Application for a Non-Material Amendment Following a Grant of Planning Permission

Erection of a single storey extension to rear, conversion of loft space with installation of roof lights to side and rear and construction of raised patio to rear

23/02963/PLF

The rear extension to have a flat roof rather than a pitched roof.

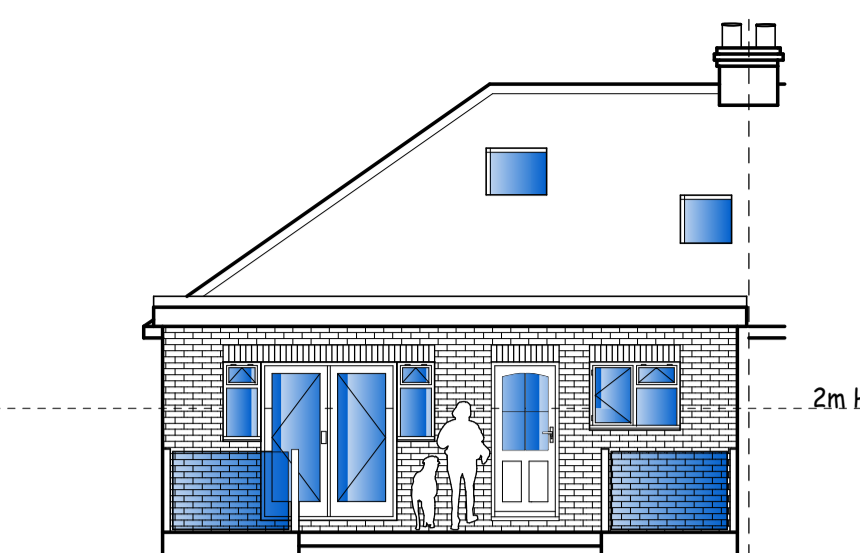
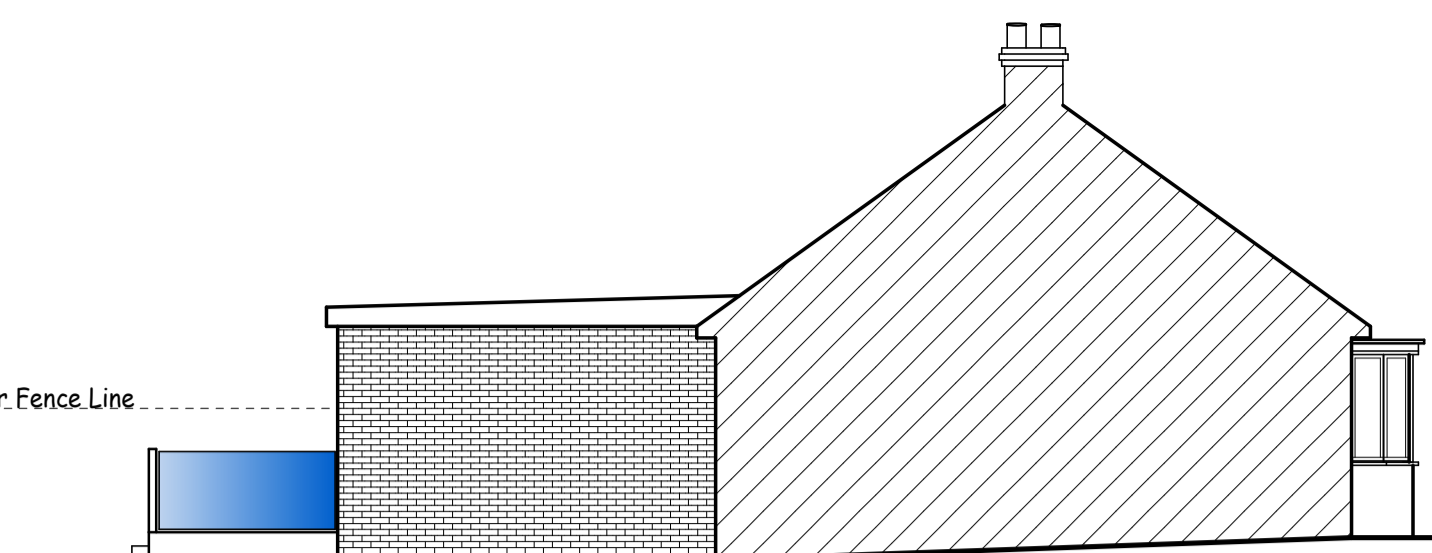
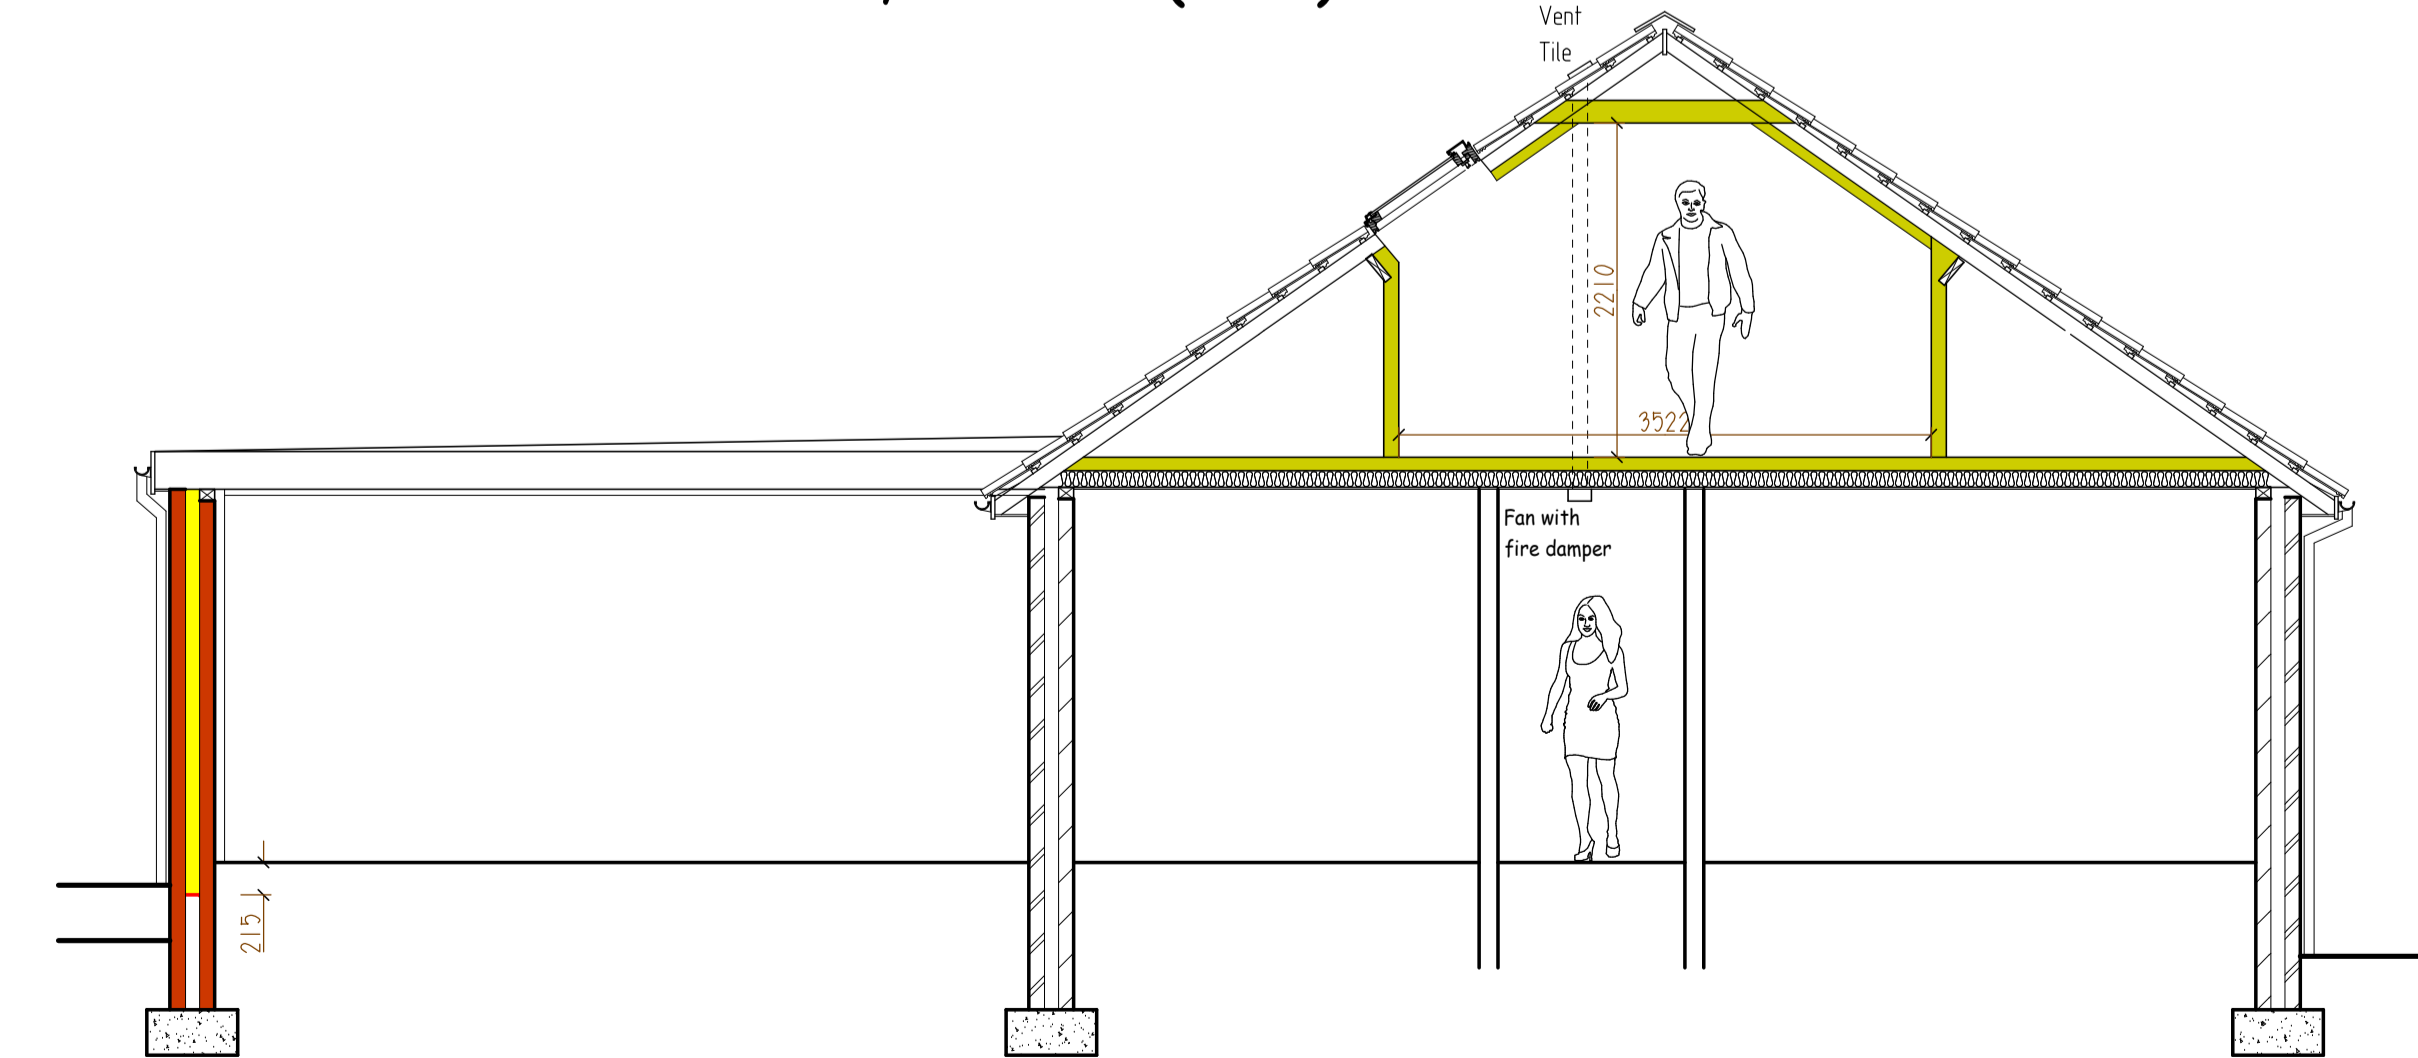
Building control have stated that the existing roof cannot support the additional load of a pitched roof from it.

2305D 3B Proposed
